Ribble Valley Borough Council
Housing & Development Control

App. no: 3/2024/0029

Address: 5 The Dene Hurst Green BB7 9QF

Proposal: Proposed two-storey extension to rear, decking to side and new vehicular access and parking area to front, changes to land levels and provision of retaining walls.

Proposed Site Layout

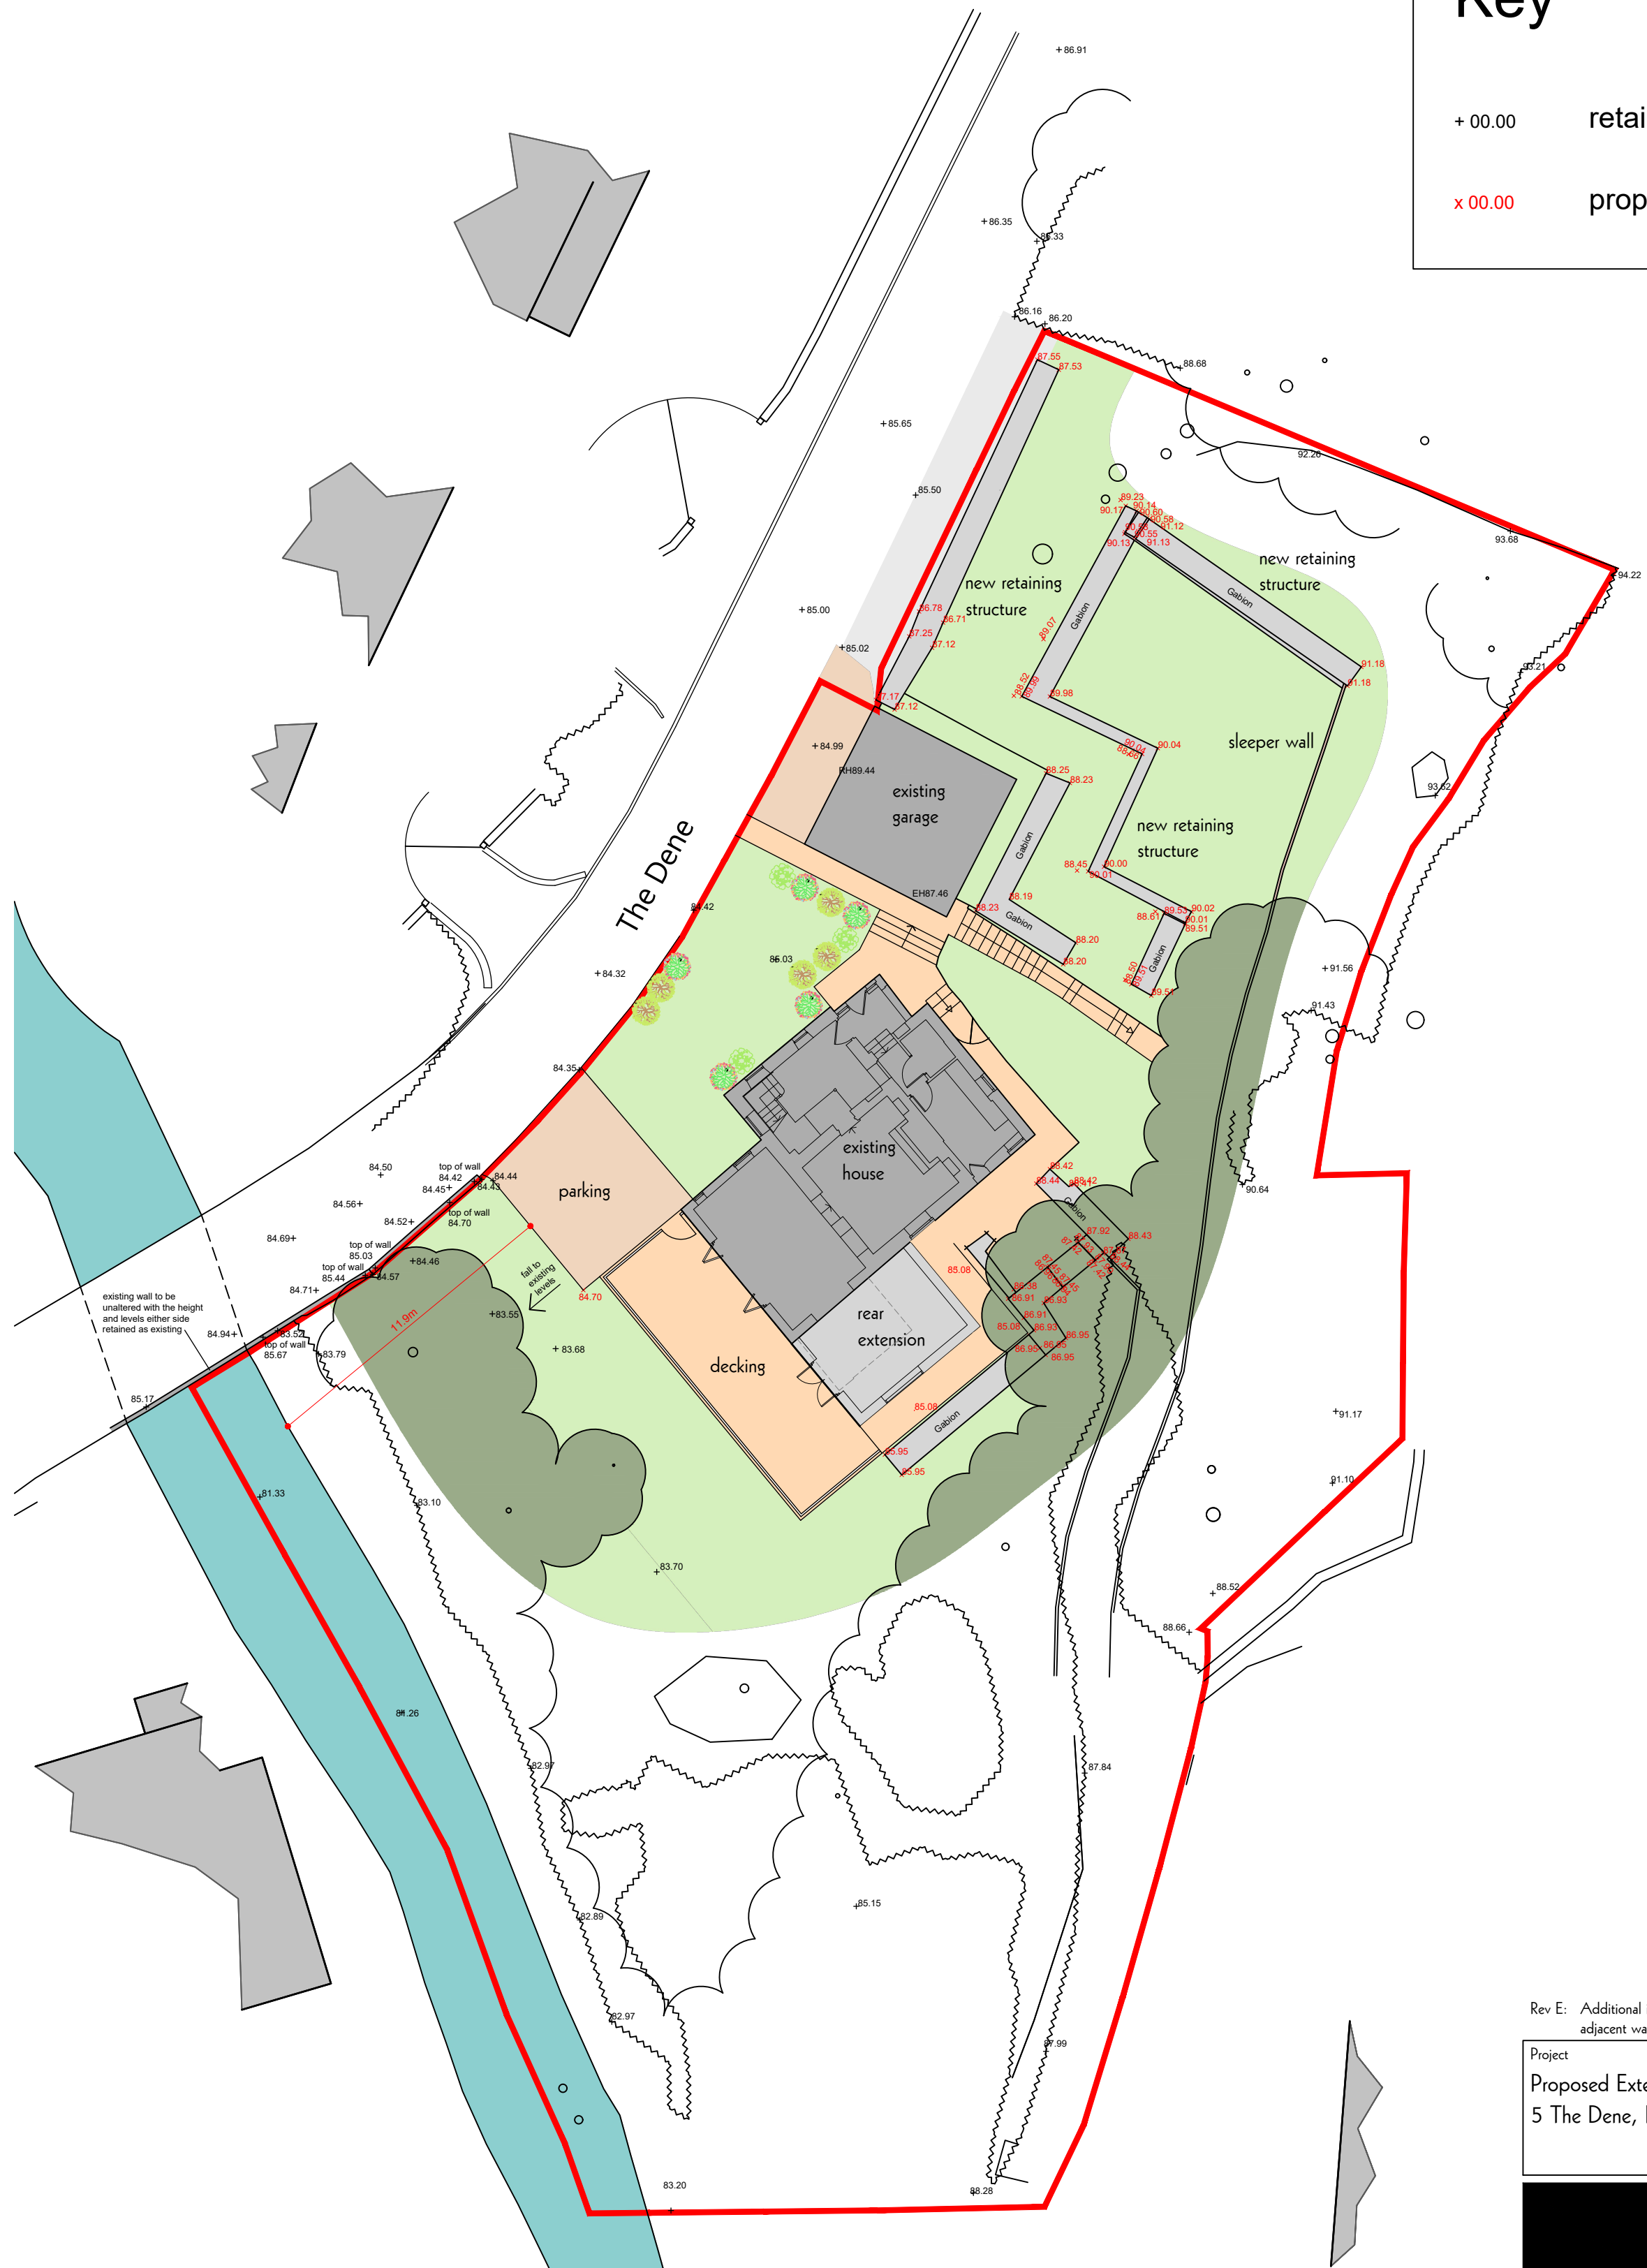
The new parking area has been reduced in size to 6m by 5.4m deep which will provide 2 side by side parking spaces.

The parking area should be paved in a bound and porous material to ensure that no loose debris or surface water is deposited onto the highway.

There are no ground level changes proposed adjacent to the bridge wall.

The new retaining structure parallel to The Dene which is set back from the adopted highway by 2m is constructed in gabion baskets. Due to the height and proximity of the structure to the highway, we would request details to demonstrate that the large structure has been designed and constructed by a suitably qualified structural engineer.

Subject to the further information being submitted regarding the design and construct of the structure by a suitably qualified person we would raise no objection to the proposal.

1. Prior to its first use the driveway shall be paved in a bound and porous material.
Reason: For highway safety to ensure that no loose debris or surface water is deposited onto the highway.
